Station Road/Huddersfield Road Visibility Drawing

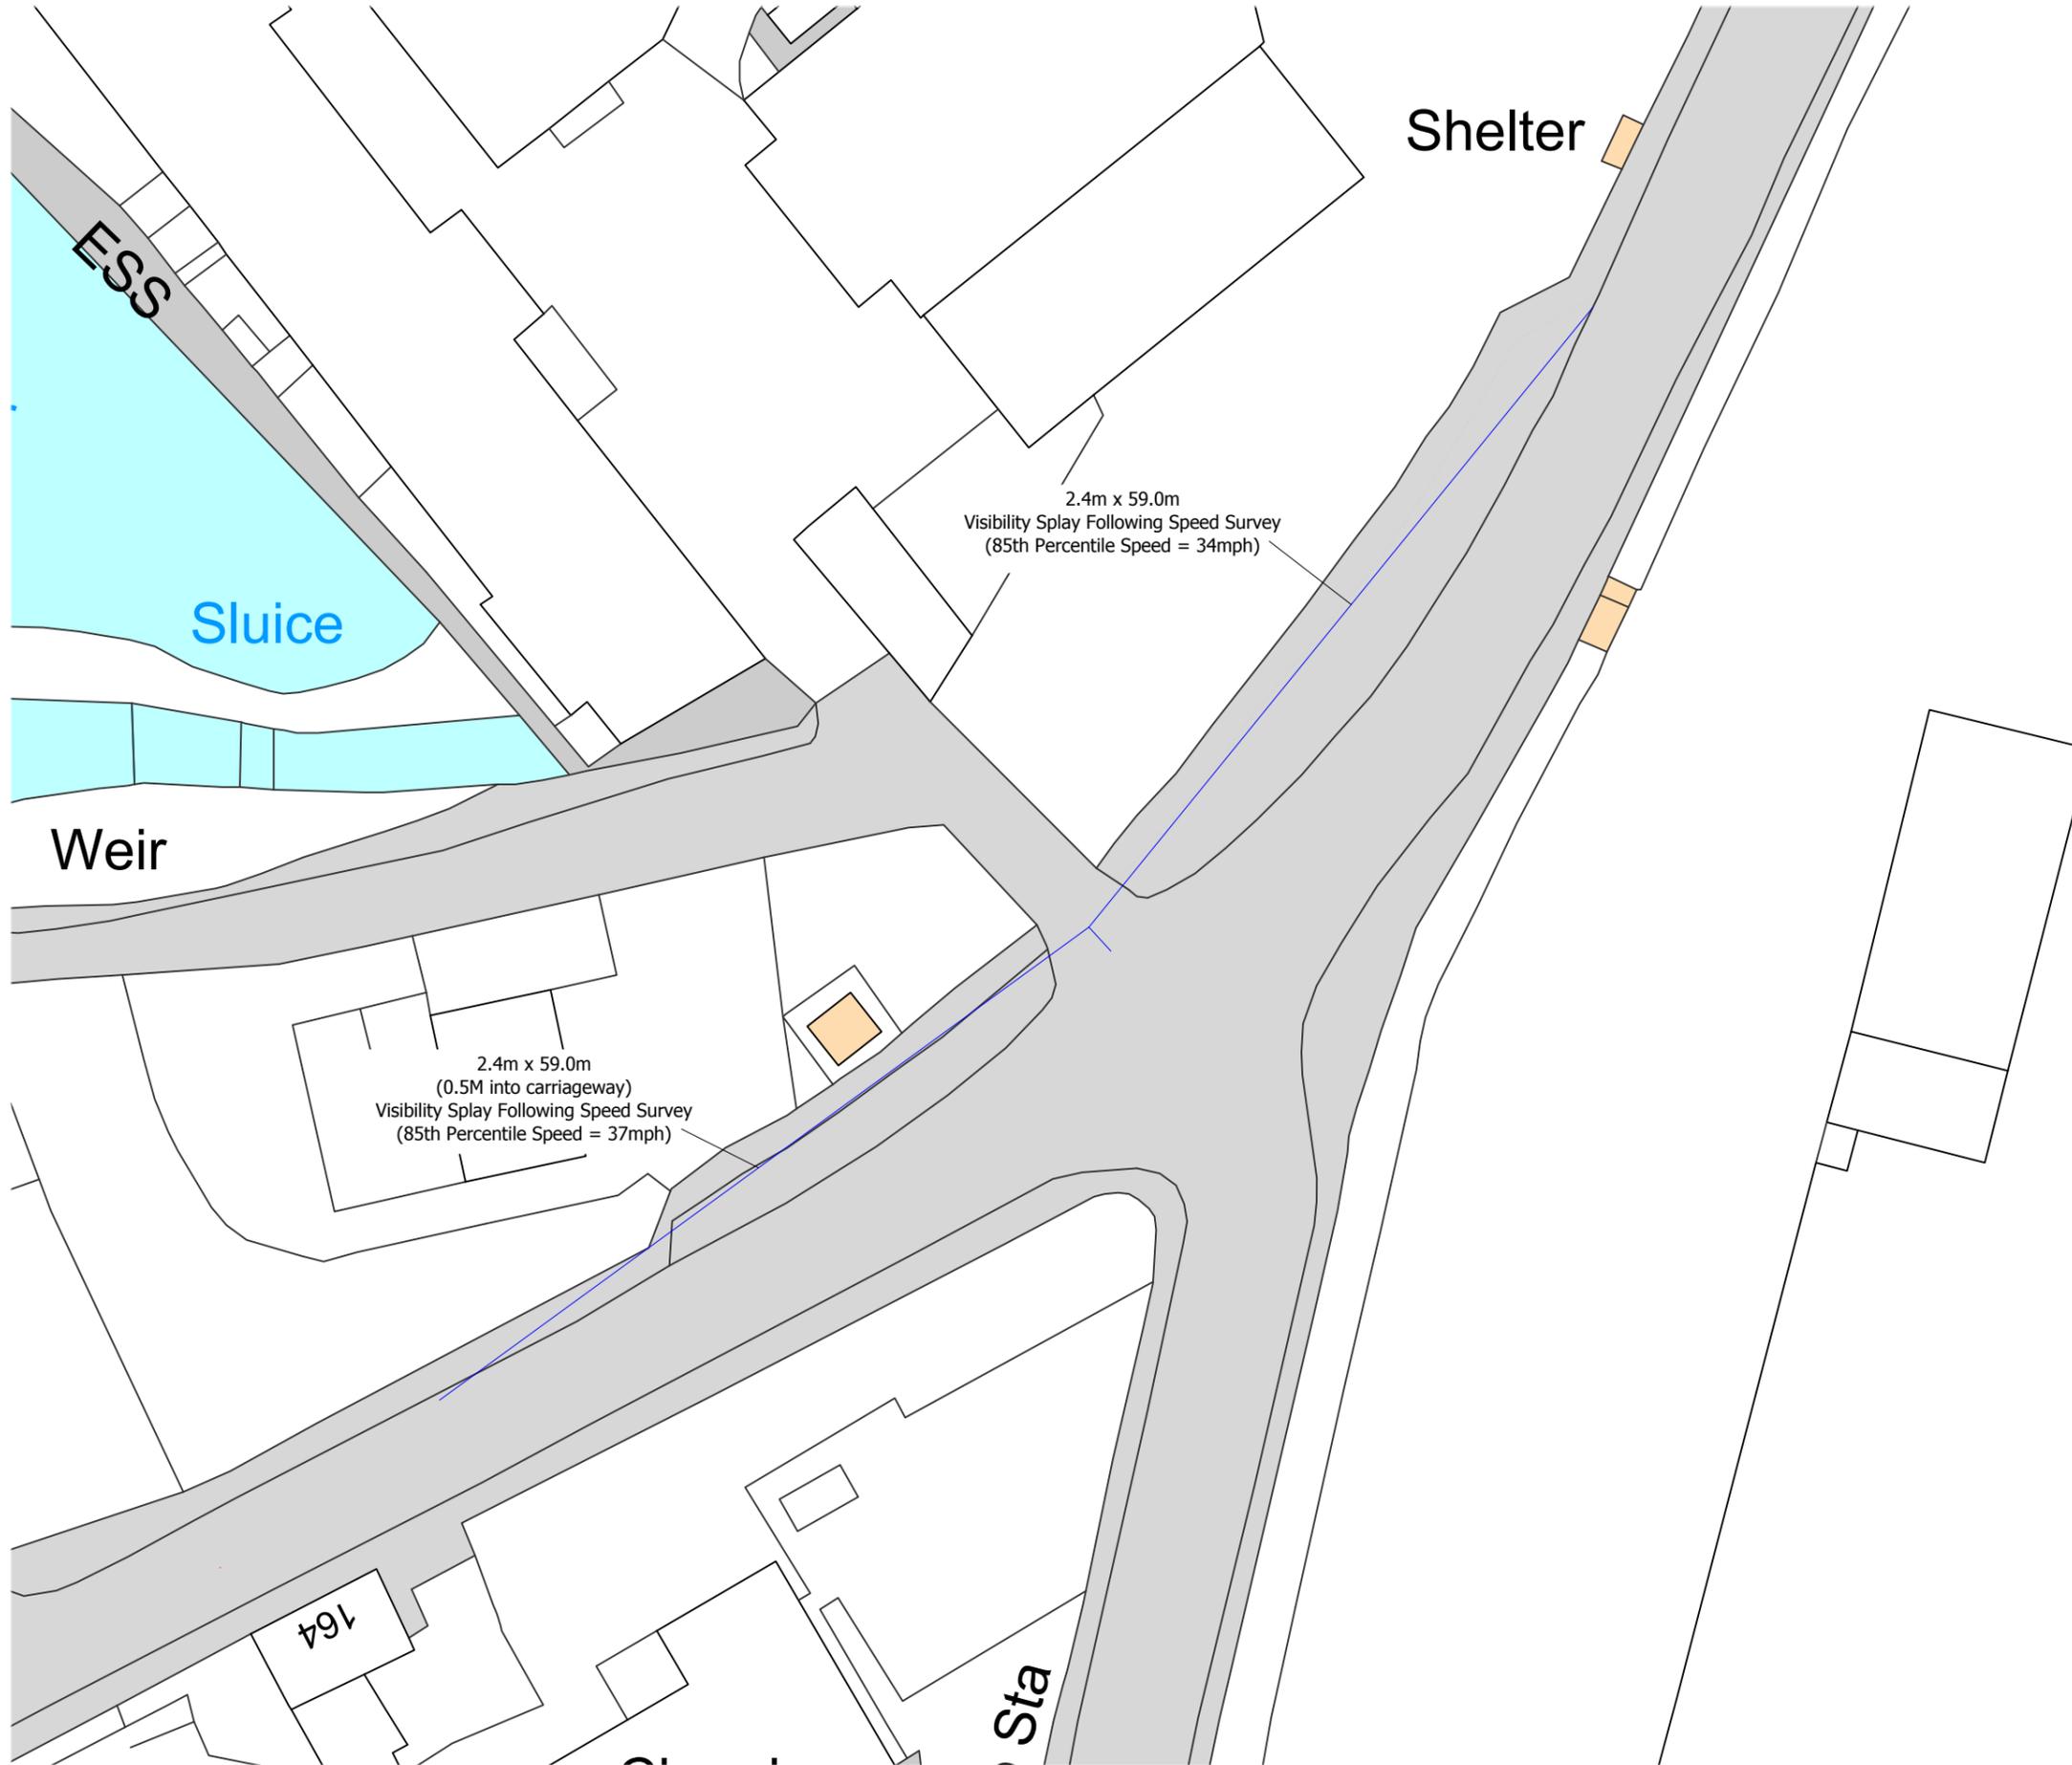
Station Road joins Huddersfield Road at a dangerous junction on a 40mph stretch of road where road use often exceeds speed limits. The junction is not wide enough to allow two vehicles to safely pass – with a badly damaged wall evidencing this. There is no pedestrian segregation.

The Station Road/Huddersfield Road junction needs remodelling and the Huddersfield Road speed limit dropped to 30mph if this estate goes ahead.

project no.	drawing no.	revision
2391	02

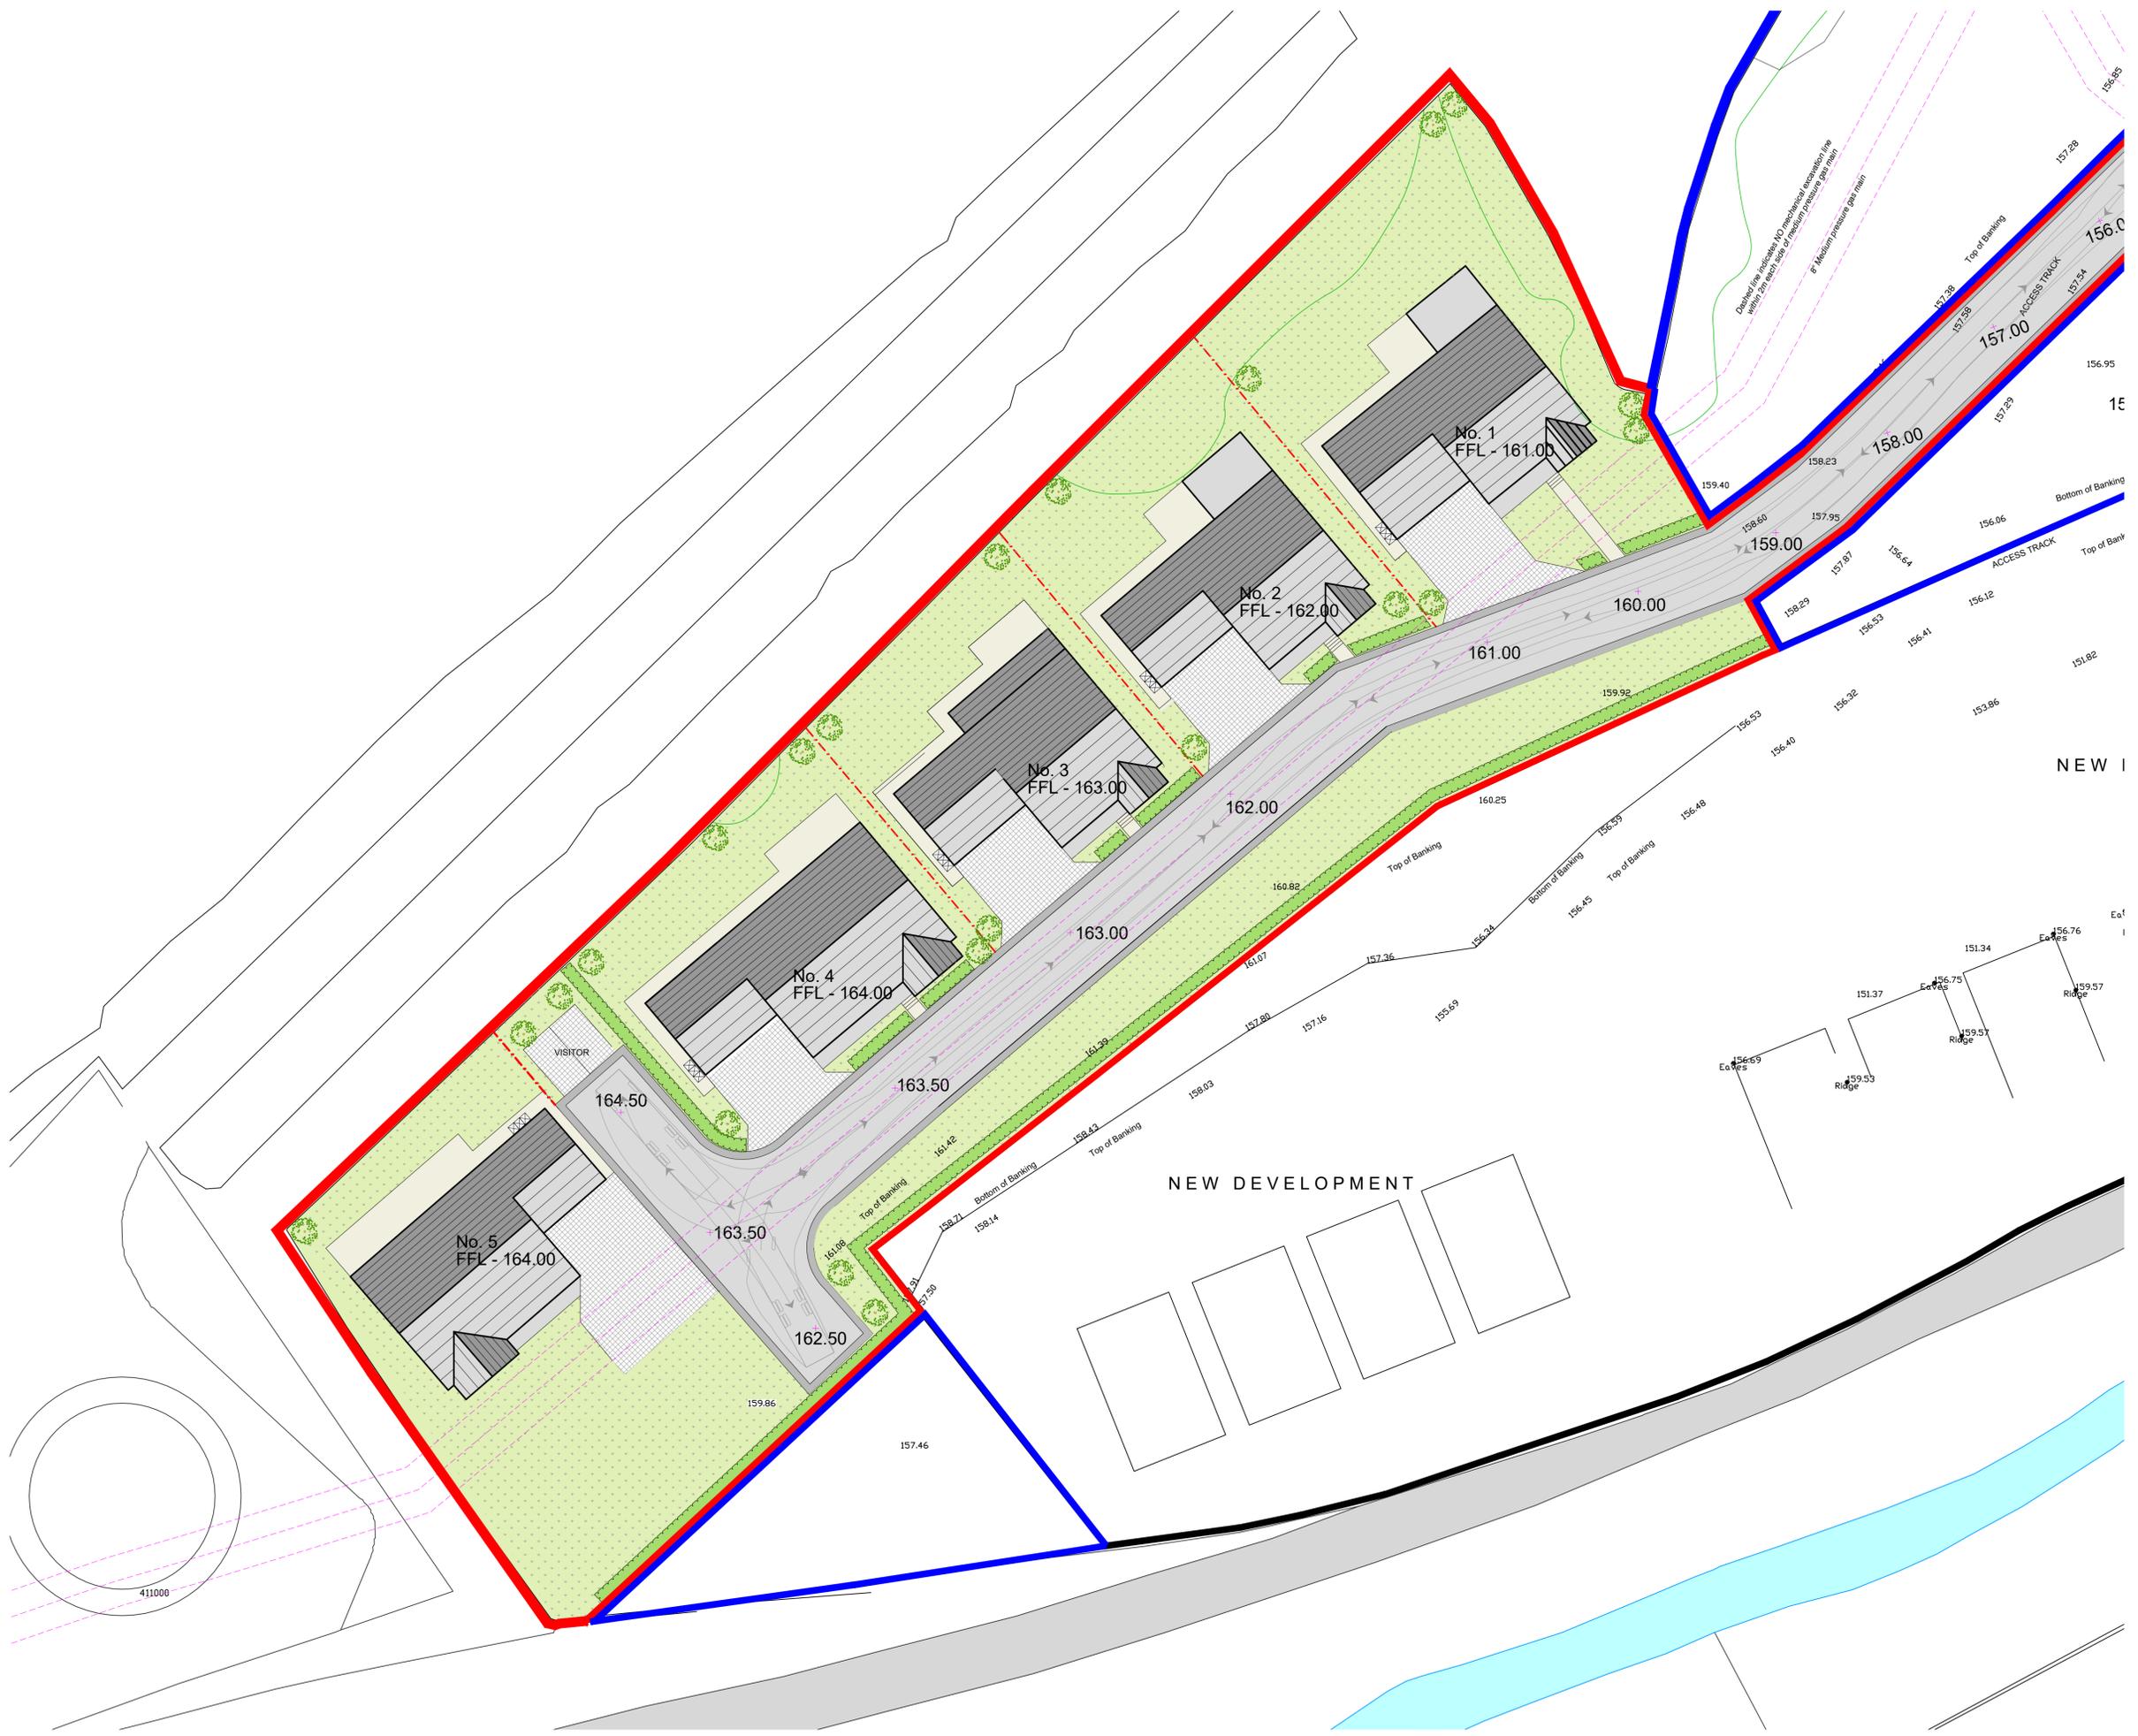
The straight layout of the road down the hillside appears impractical. The sinuous haul road created for the recent estate construction, loops through the blue lined land on the map, because of the topography.

The nearby steep Woodland Walk road regularly ices over during the winter. There has been at least one runaway accident and residents are often forced to park at the estate entrance during the winter given the road conditions. The new estate road design creates similar road user risks.
